From: Andrew Robley
Sent: 28 April 2017 12:47
To: Sam Dicocco <s.dicocco@welhat.gov.uk>
Subject: FW: H191 RE: 6842_170314_Oshwal Centre_rear extension_final solution_01_fr
paolo_6842_C7

6/2016/0347/LB

These drawings are acceptable in my opinion.

DRAWING NO. 6842-36-P3

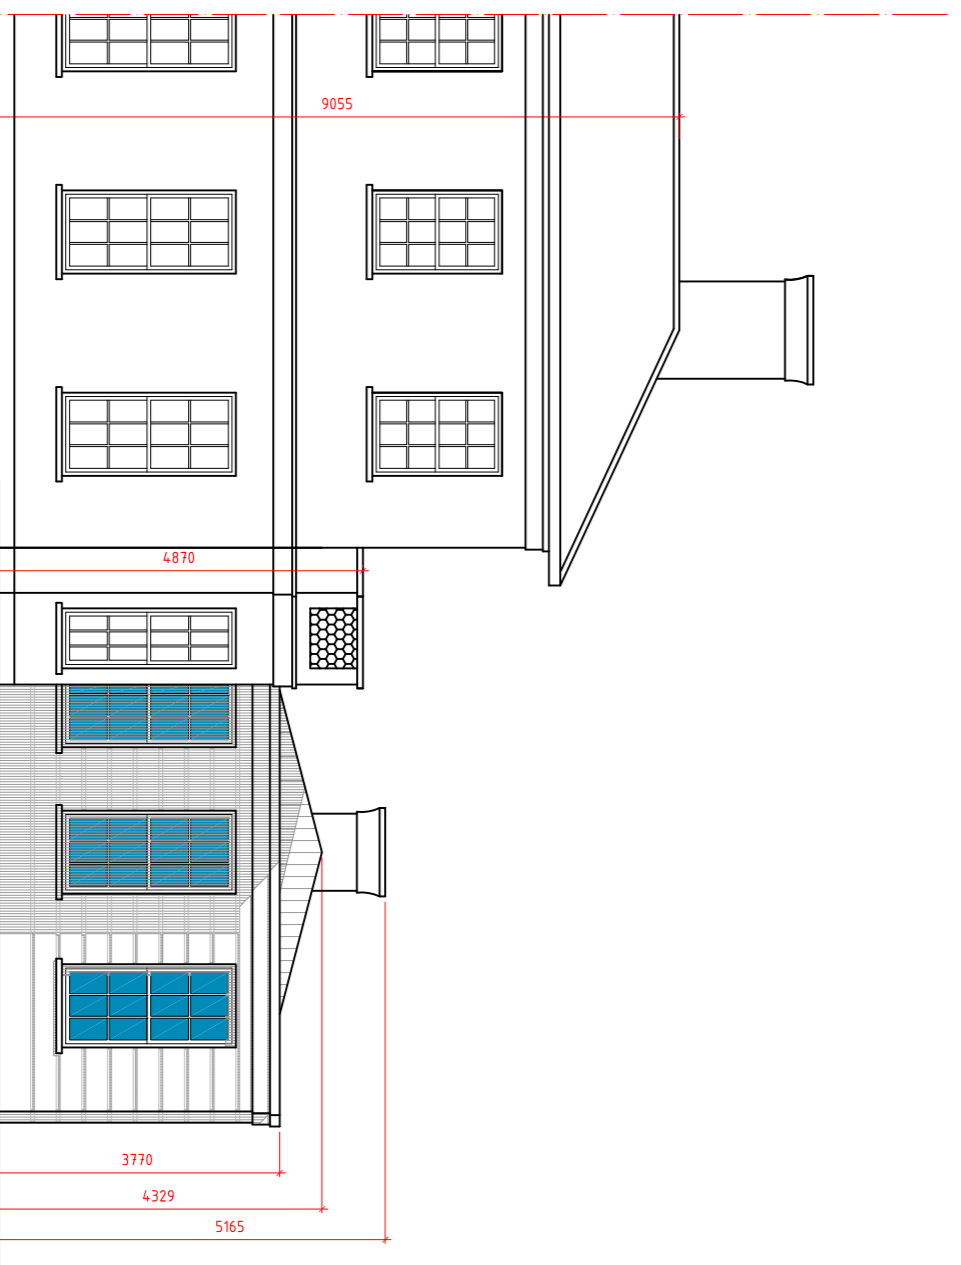
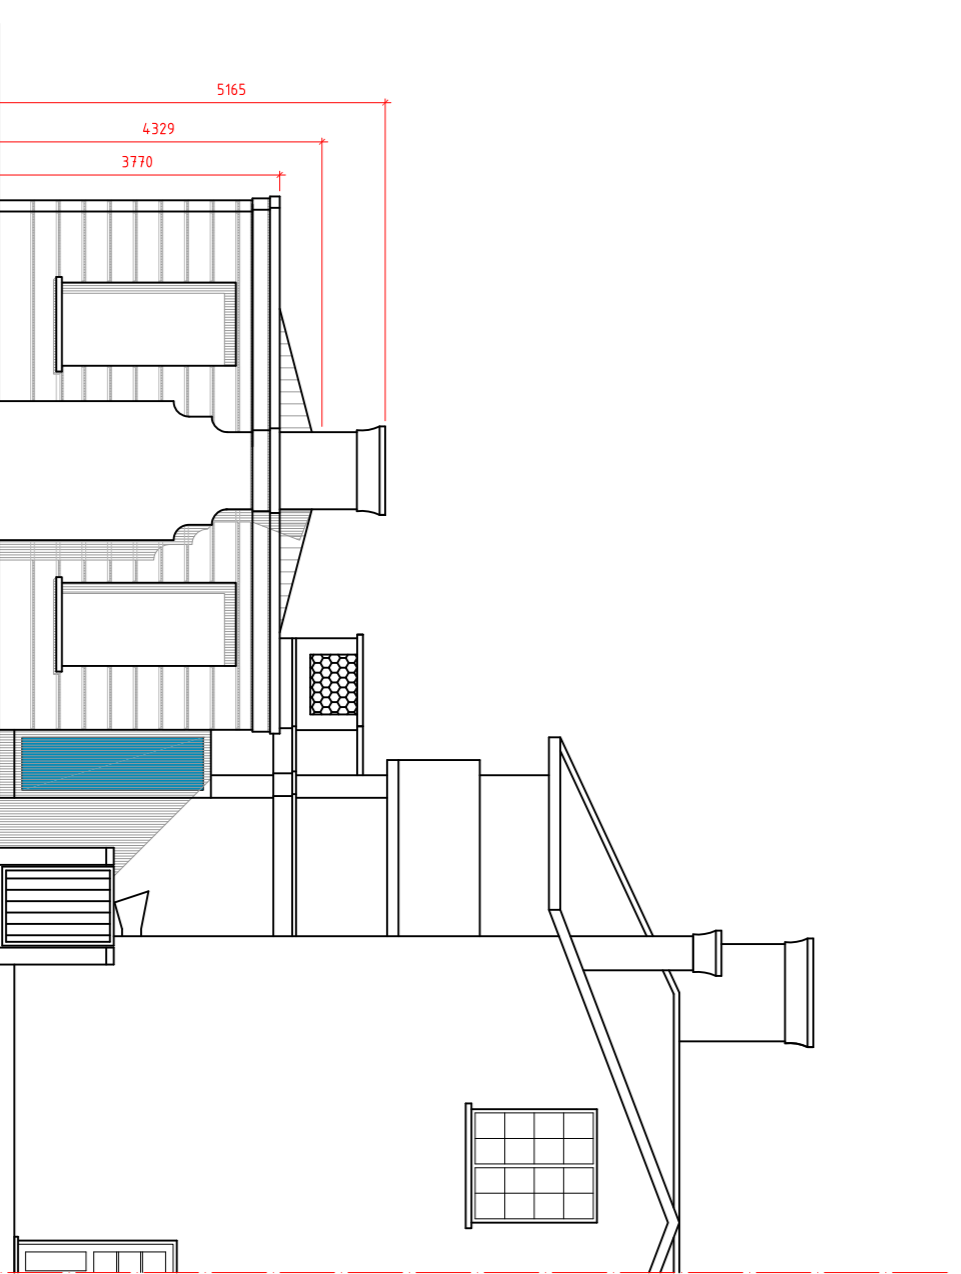
As I hinted, the glazing bars for the French doors may have to be modified because it is unlikely that the number of panes shown would fit in without becoming too fussy. However we could control this by specific conditions.

Notwithstanding the approved drawings, the glazing pattern of the French doors should be re-considered as part of the above condition

Prior to the commencement of any works on site, precise details of the following must be submitted to and approved in writing by, the Local Planning Authority; a) roof parapet/cornice, gutter, abutments with existing building and hips at 1:5 scale; b) windows/doors, 1:20 elevations and 1:2 sectional details, c) roof lights 1:20 plans, 1:5 details.; d) Junctions with existing buildings 1:5 scale; Chimney stack/flue 1:20 elevation 1:5 sections.
